SEEGER HOMES INC. - SALES OFFICE

SPECIAL USE PLANS LOT 3, APPALOOSA HIGHWAY 24 SUBDIVISION

SALES OFFICE - SPECIAL USE
SITE PLAN

SHEET NO:	C-01
DATE:	10/24/18
PAGE NO:	1 OF 1

SHEET NO. C-01
DATE: 05/25/18
PAGE NO. 1 OF 1

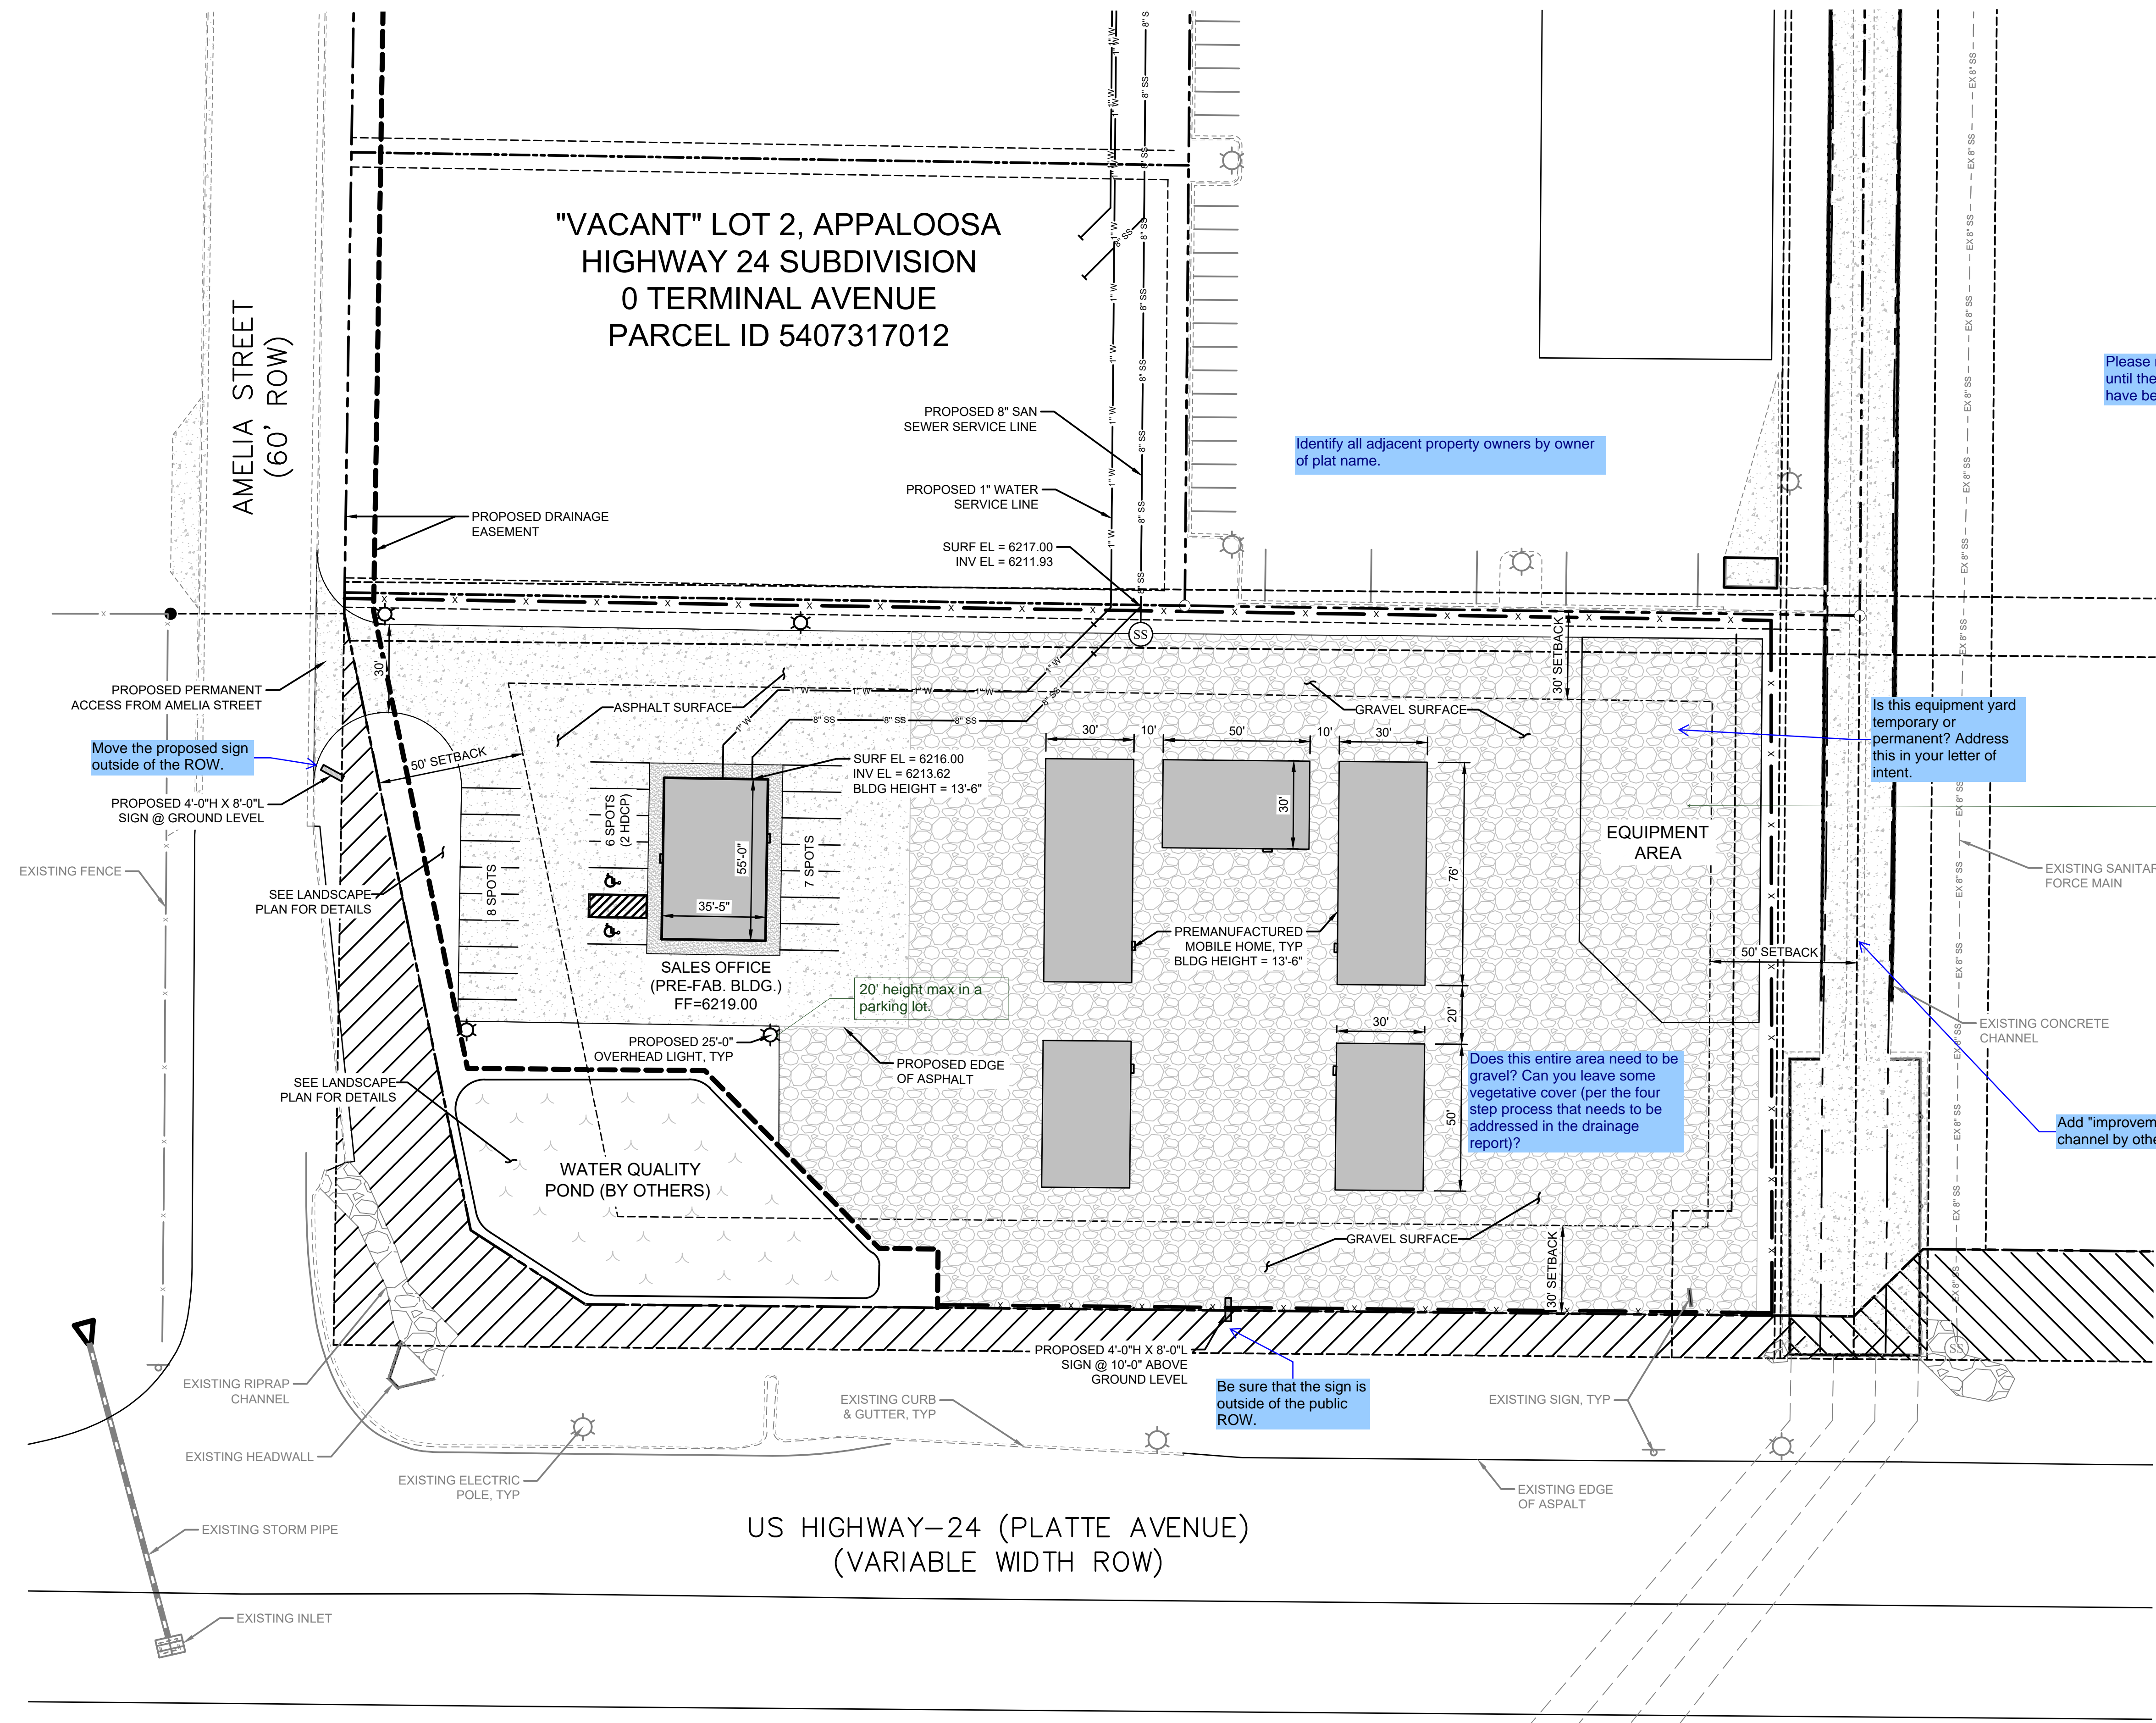
"VACANT" ← This is not a vacant lot. Please revise.

This should be File No. AL1811

This is not a vacant lot. Please revise.

This should be File No. AL1811
